DEVELOPMENT CONSENT ORDER EN010012 : THE SIZEWELL C PROJECT

ISSUE SPECIFIC HEARING 12 WEDNESDAY 15
SEPTEMBER 2021

3 September 2021

PUBLIC RIGHT OF WAY BRIDLEWAY 19 LEISTON cum SIZEWELL

DRAWING TITLE:
 CONSTRUCTION PHASE

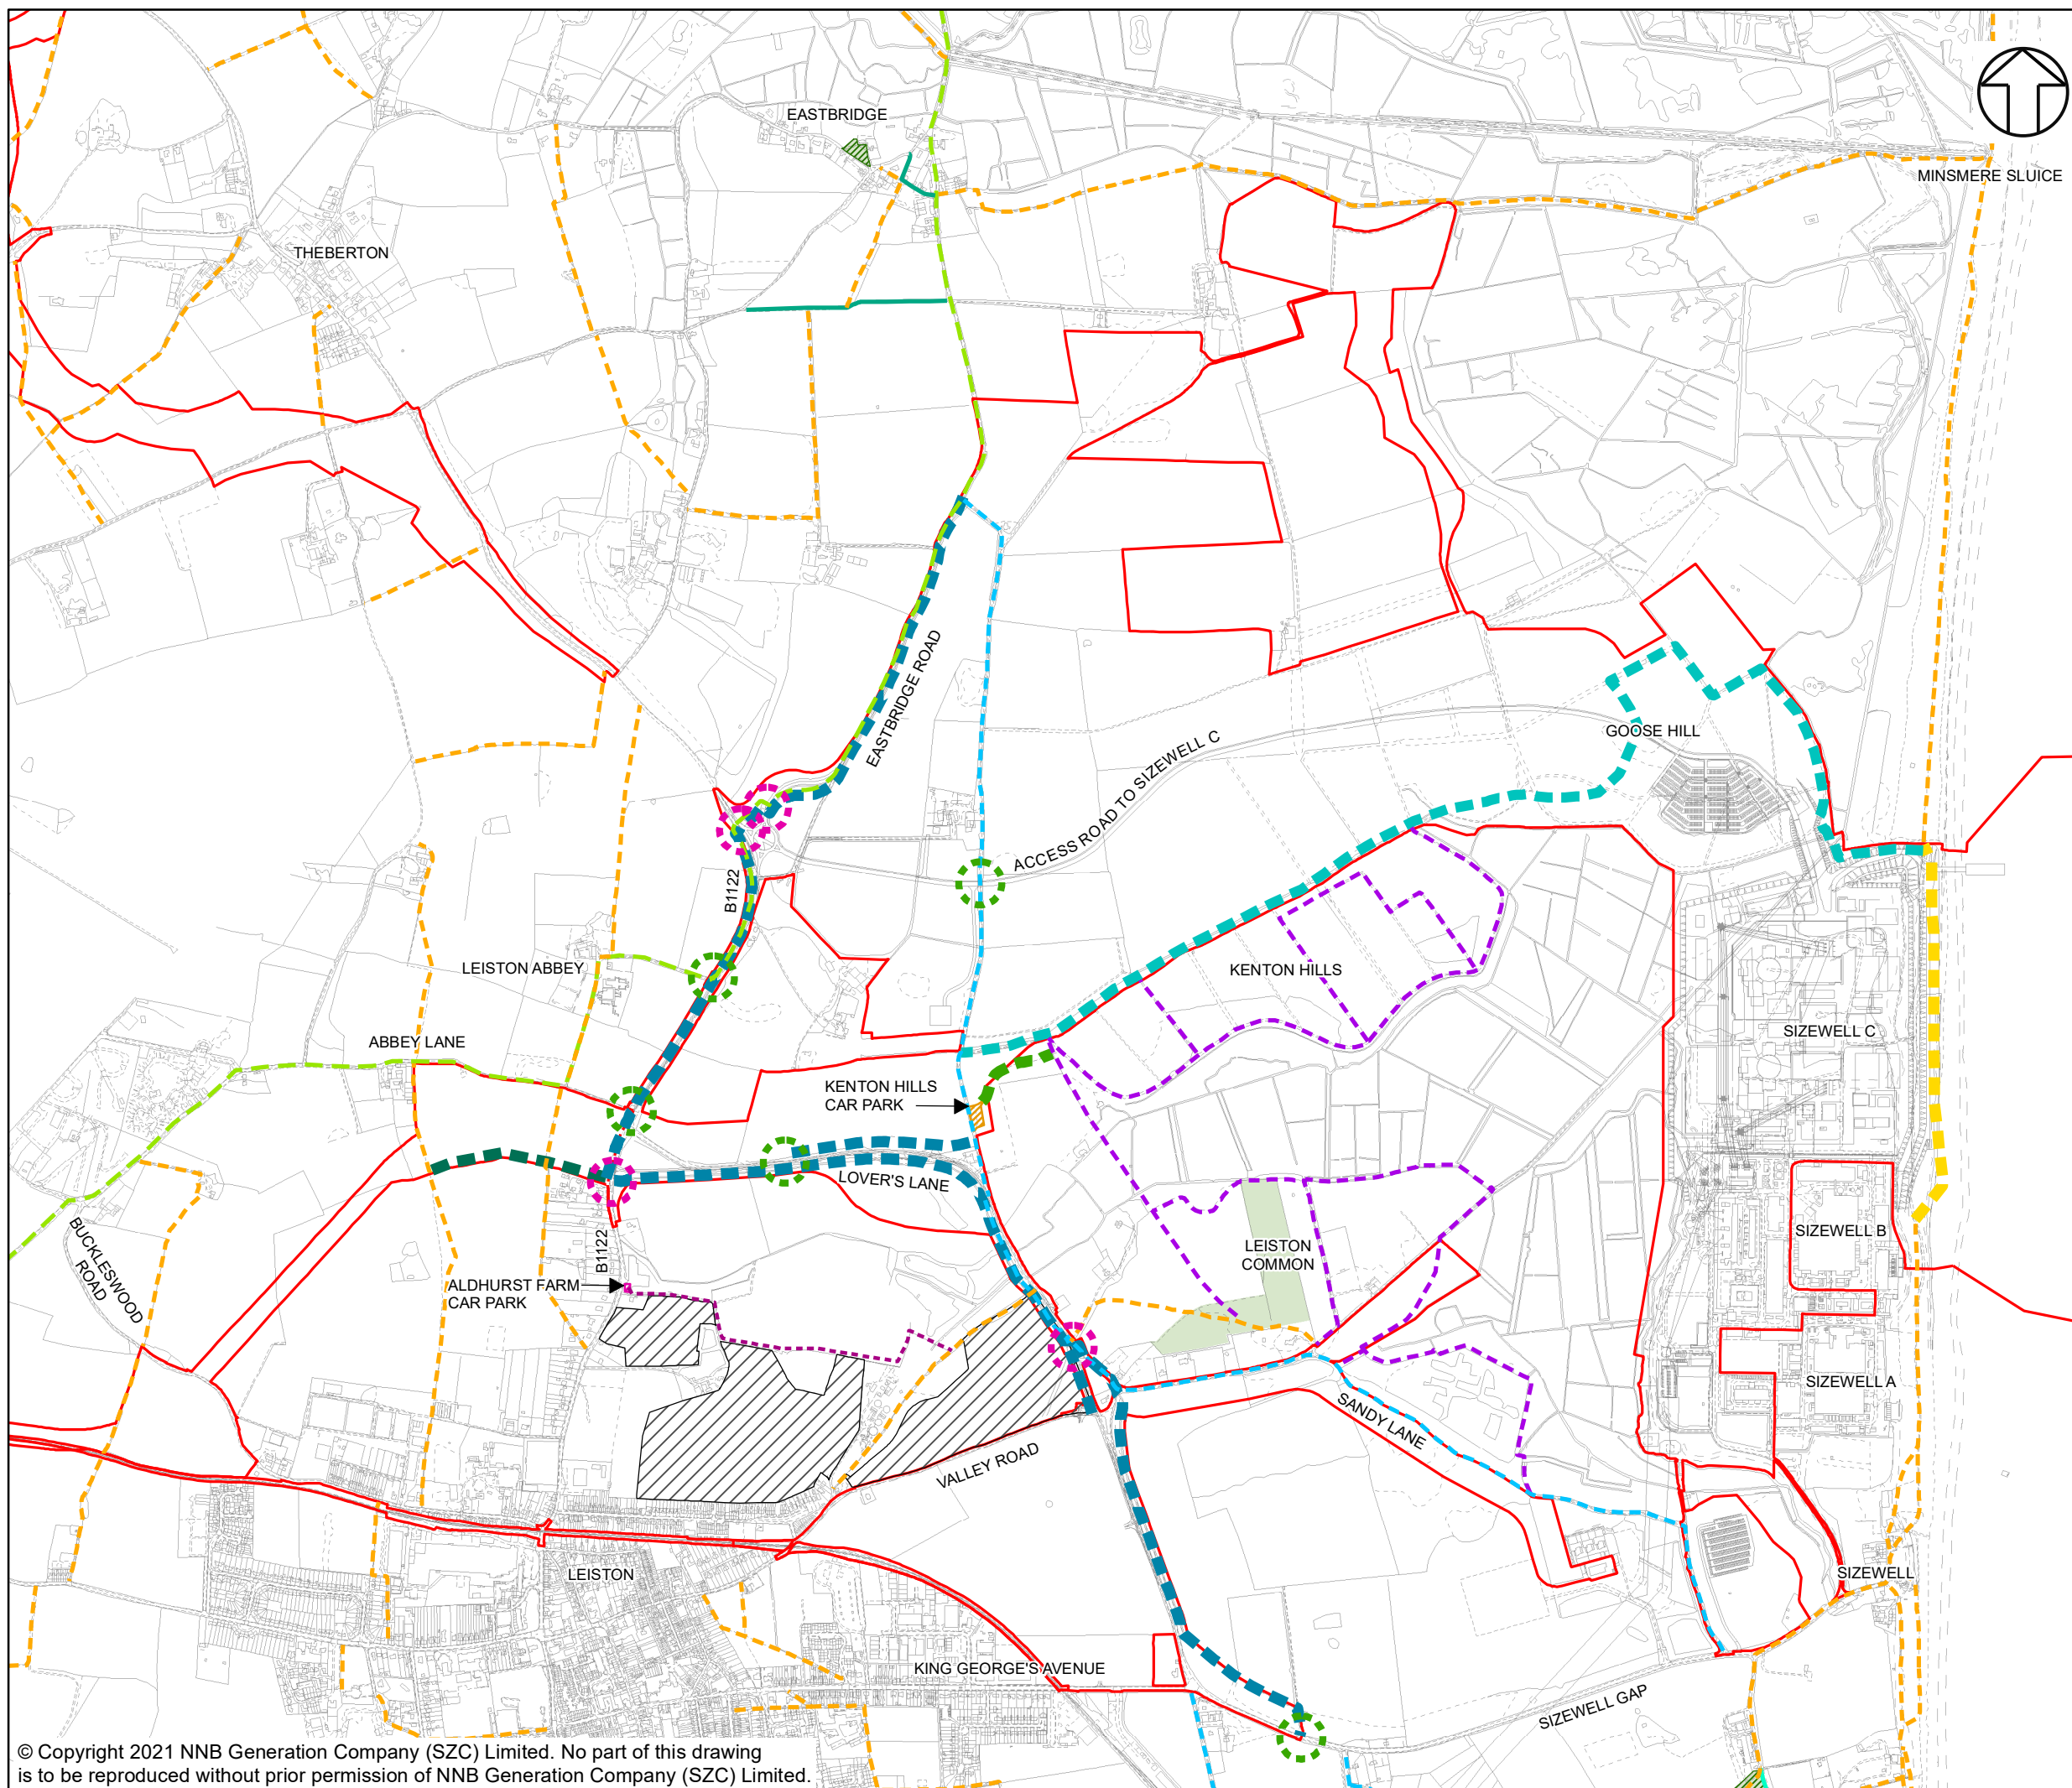
The proposed diverted route for **BR19**, which would also include the temporary diversions of the Suffolk Coast Path and the Sandlings Walk, was identified at an early stage in [\(APP 270\)](#) **Environmental Statement Volume 2 Chapter 15 Amenity and Recreation** and shown in **Appendix 15I Figure 15I.2.** (page 118)

1.2.16. The new off-road bridleway would be constructed prior to the closure of the Coast Path and temporary diversion of bridleway 19 and closure of bridleway E-363/013/0.

As has been shown from the various submissions made by NBB Generation Company (SZC) Ltd no safe alternative route would be provided during the entirety of the construction period that was open, safe and usable by the horse riders who currently enjoy free access along **BR19**.

However, the only possible alternative route for **BR19** will not be available until the end of the initial construction stage. As **BR19** is located within the construction site, the route cannot safely remain open to the public during the construction of the alternative route.
